<b>Application Ref:</b>	3/2021/0578	 Ribble Valley Borough Council <a href="http://www.ribblevalley.gov.uk">www.ribblevalley.gov.uk</a>
<b>Date Inspected:</b>		
<b>Officer:</b>	AD	
<b>DELEGATED ITEM FILE REPORT:</b>		<b>Decision</b>   <b>Approval</b>

<b>Development Description:</b>	Discharge of Condition 10 (Specifications of replacement windows) and Part Discharge of Condition 6 (Recording of First Floor) of Listed Building Consent 3/2020/0763.
<b>Site Address/Location:</b>	20-22 Talbot Street Chipping PR3 2QE

PHOTOGRAPHIC RECORD OF FIRST FLOOR STRUCTURE: PHASE 1 REPORT

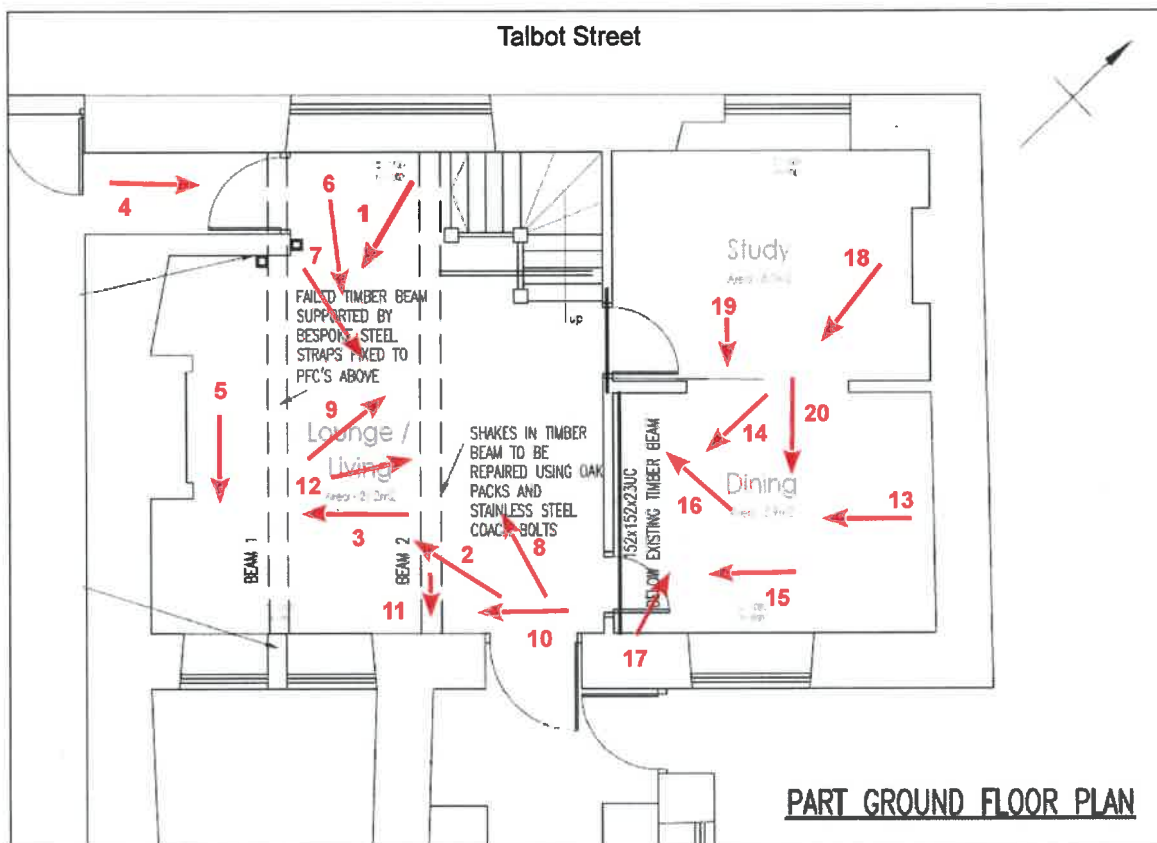
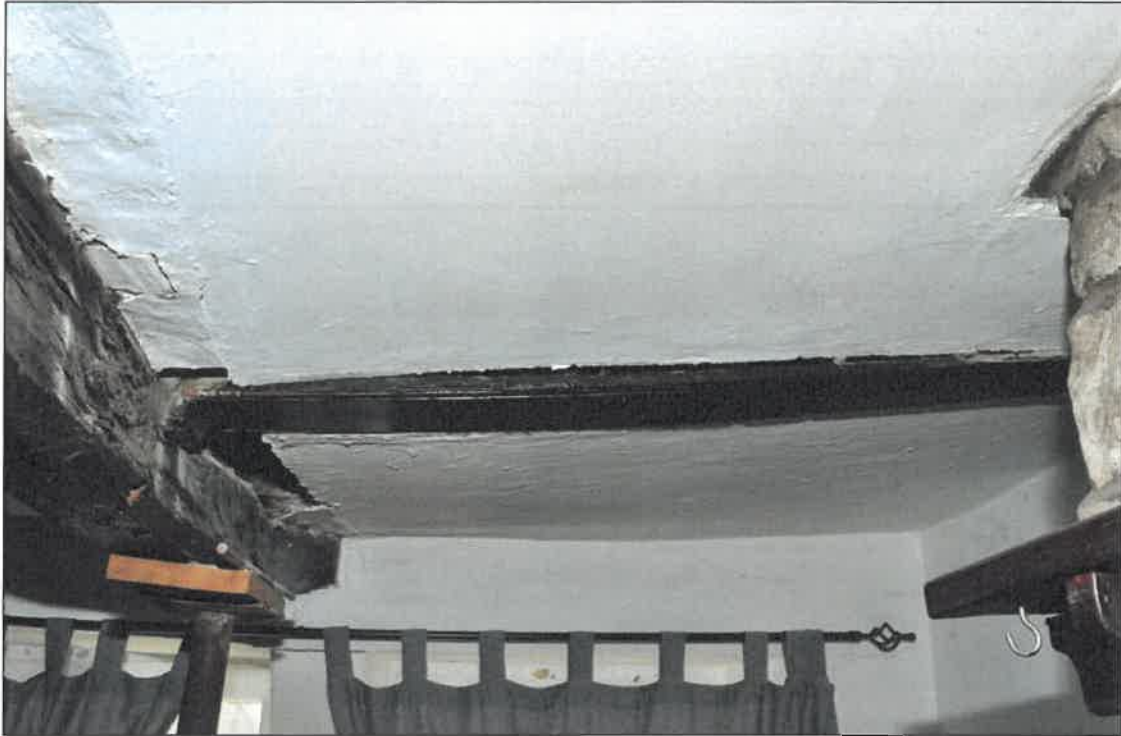
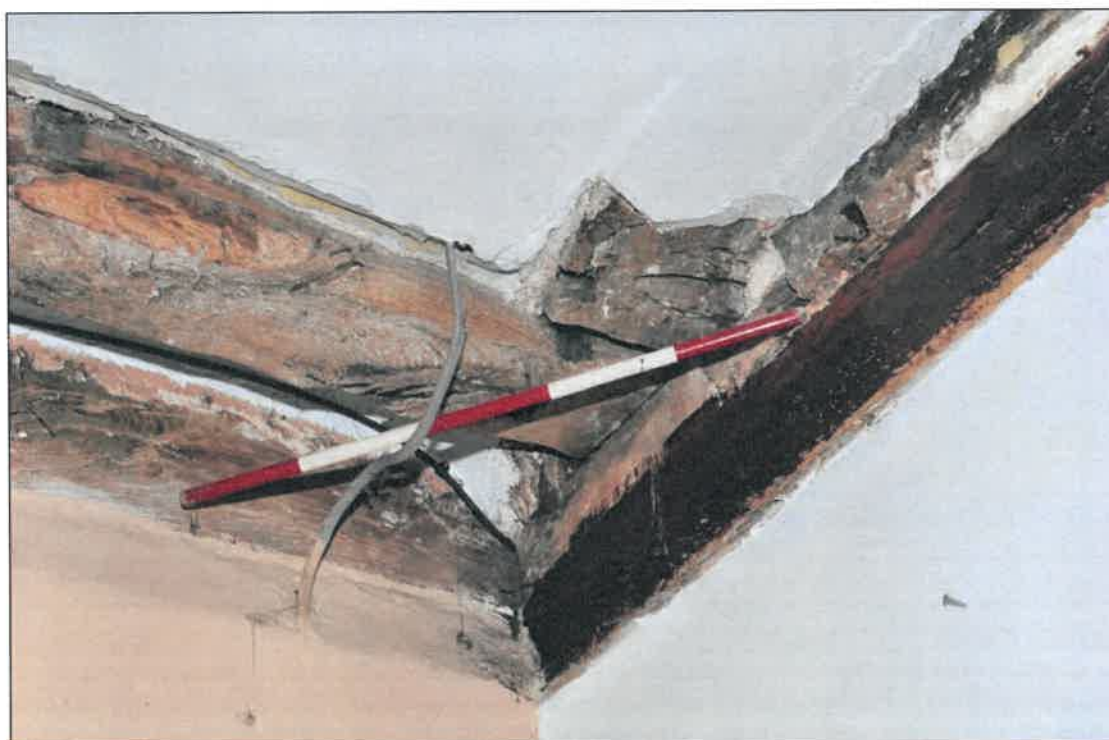
The supplied record of the first-floor beams 'as existing' appear appropriate and adequate. A full timetable for the works has not been supplied (section 4), but the intention to return and document the features during the works is noted. It is recommended that the resent report be approved, but that the condition not be discharged until the further recording has been undertaken and a revised report received.

Recommend that the first report be approved (part discharge of condition 6).

Part discharge of condition 6 (first report only).

drawing title:
ELEVATION DRAWINGS

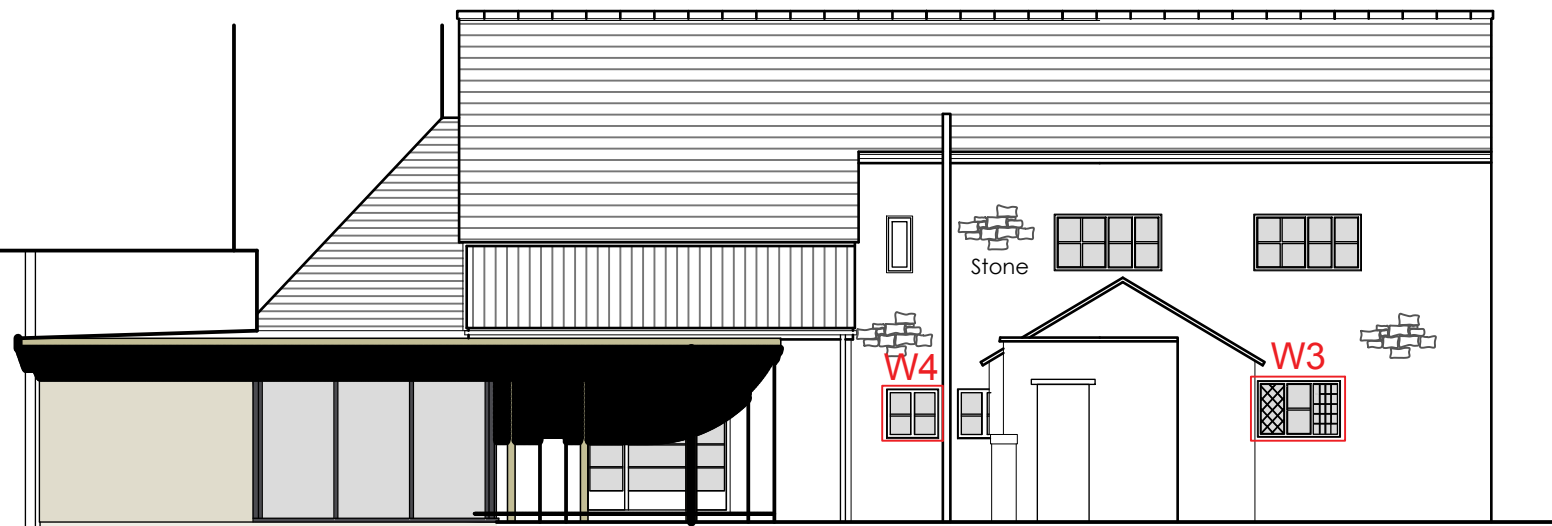
Precise specifications (scaled elevation and sectional drawings) of replacement (like – for – like) windows have not been submitted and the condition cannot be considered further at this time.
